ENG-SF22013-R1-FDR.pdf Markup Summary

Reference PCD project No CDR-20-004 -
<https://epcdevplanreview.com/Public/ProjectDetails/152502>

WATER QUALITY CAPTURE PLAN

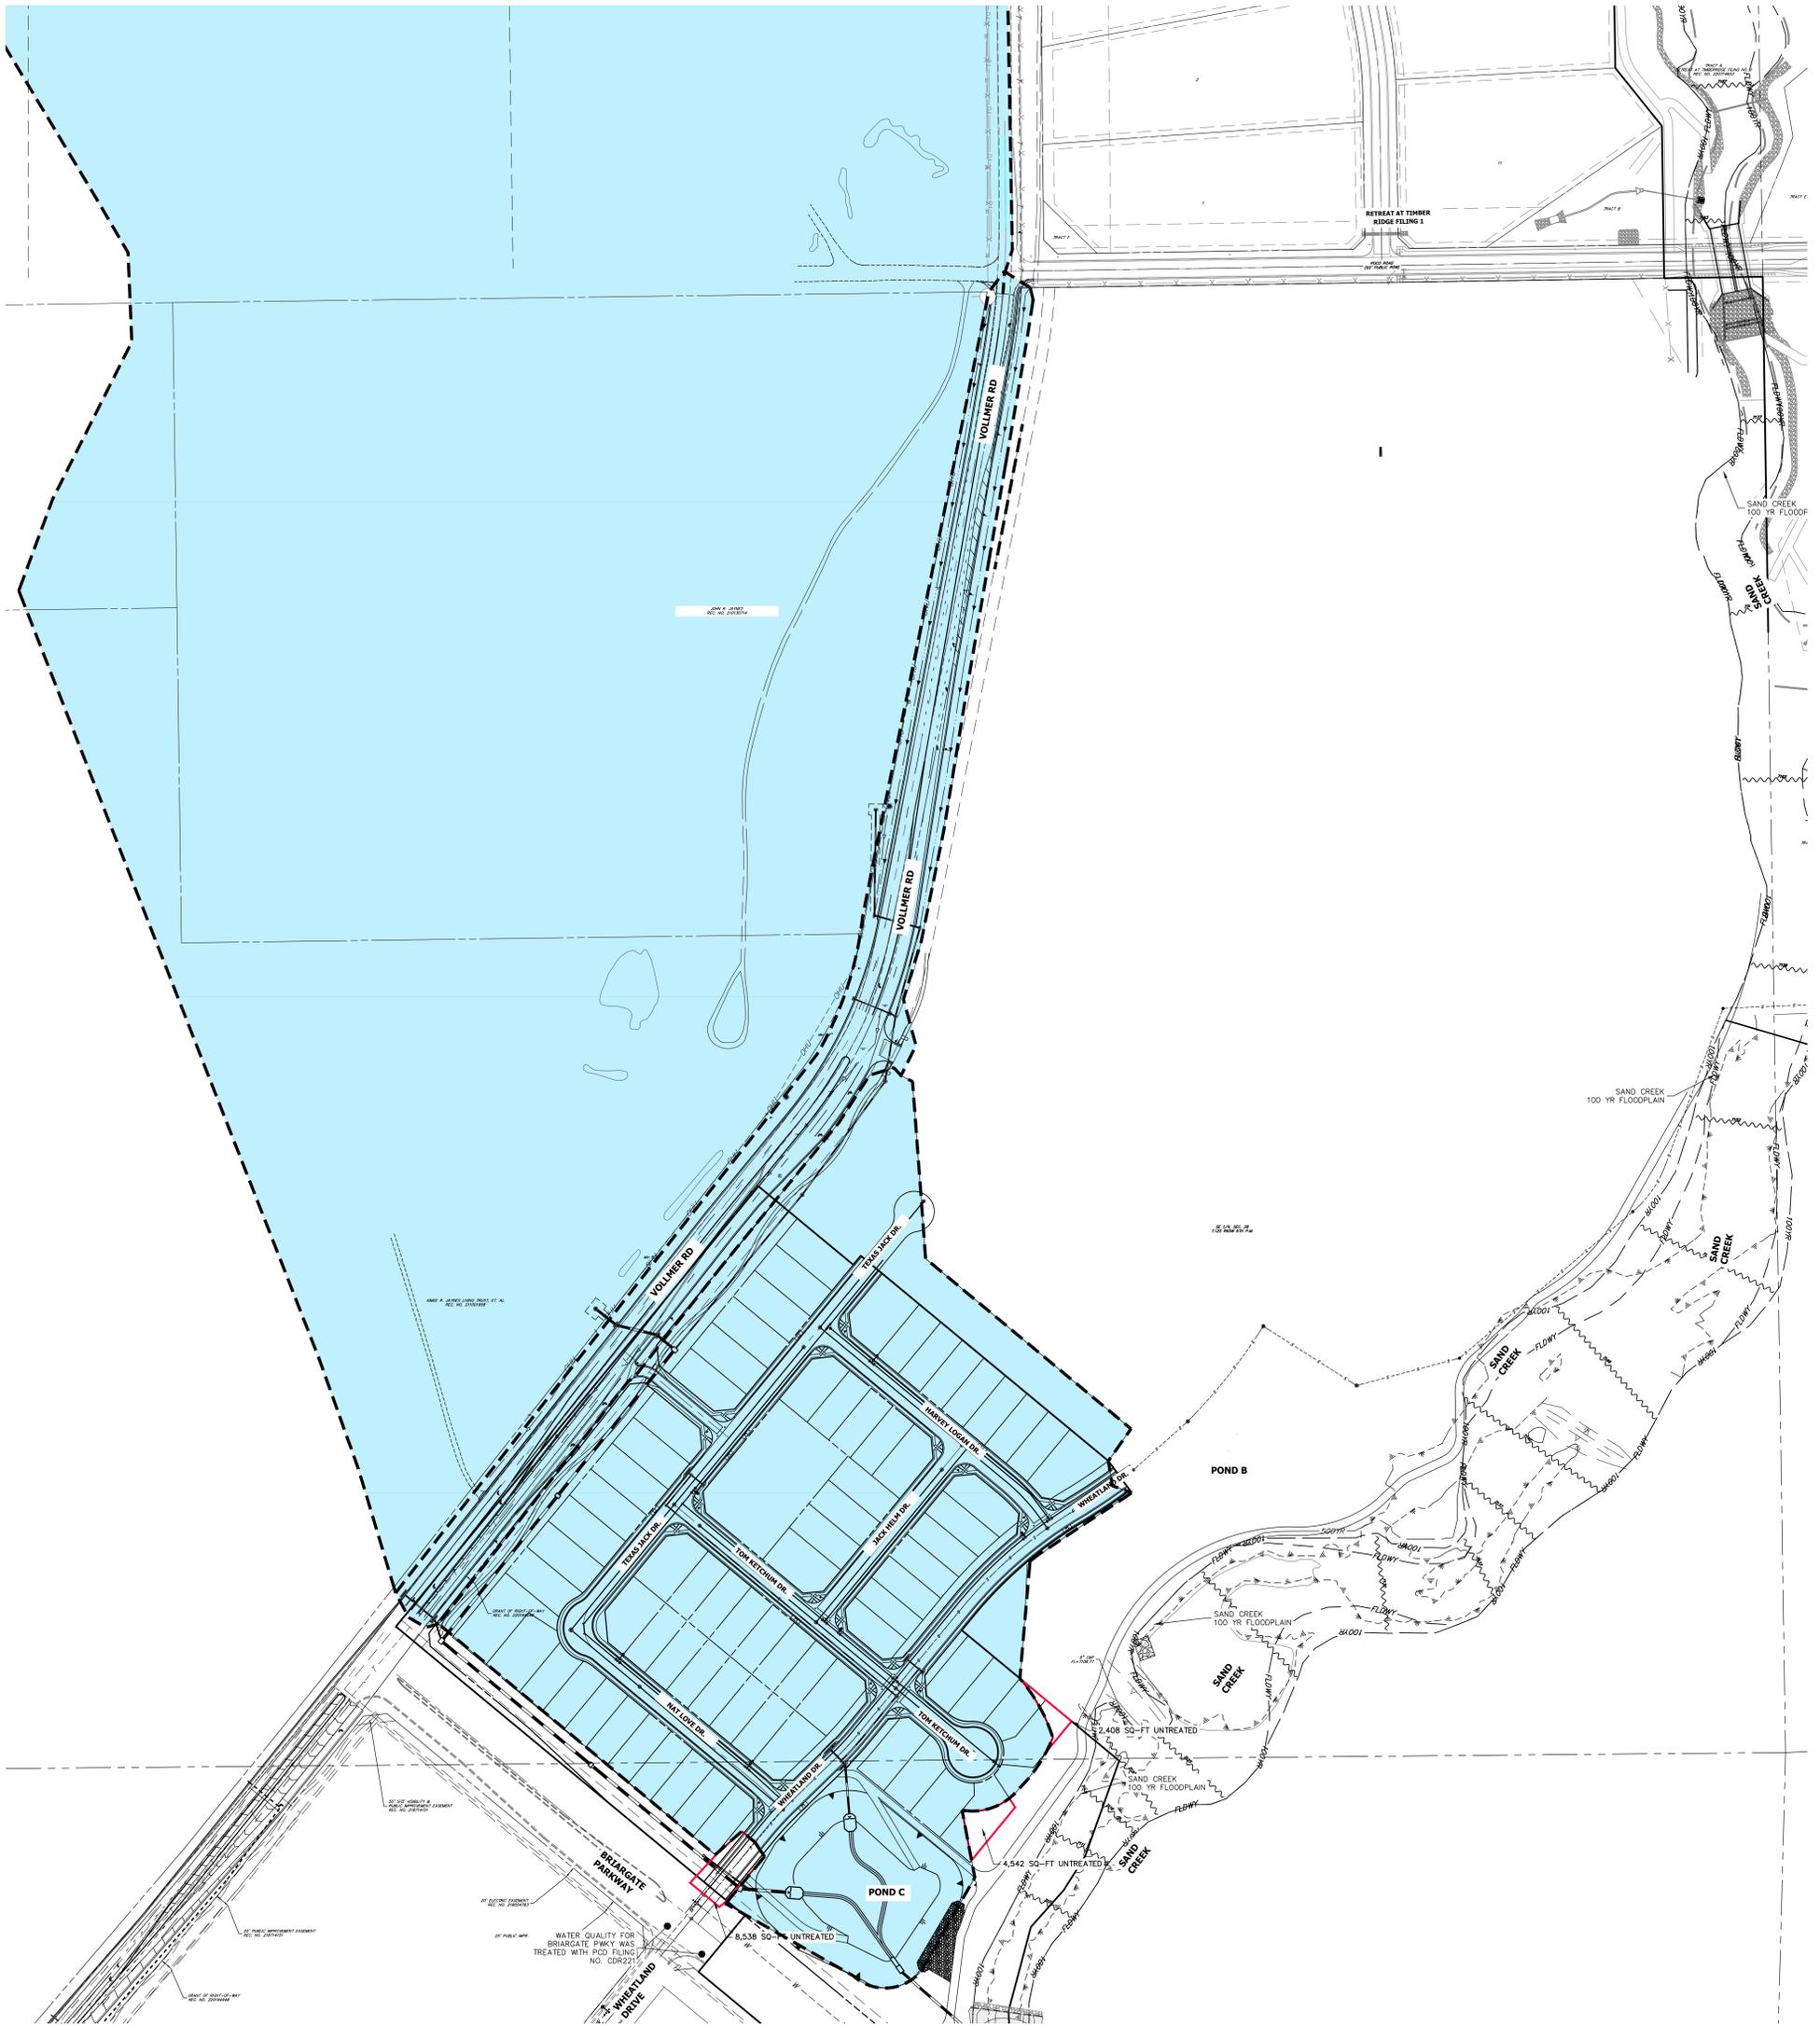
Provide a WQ plan showing where all areas are treated
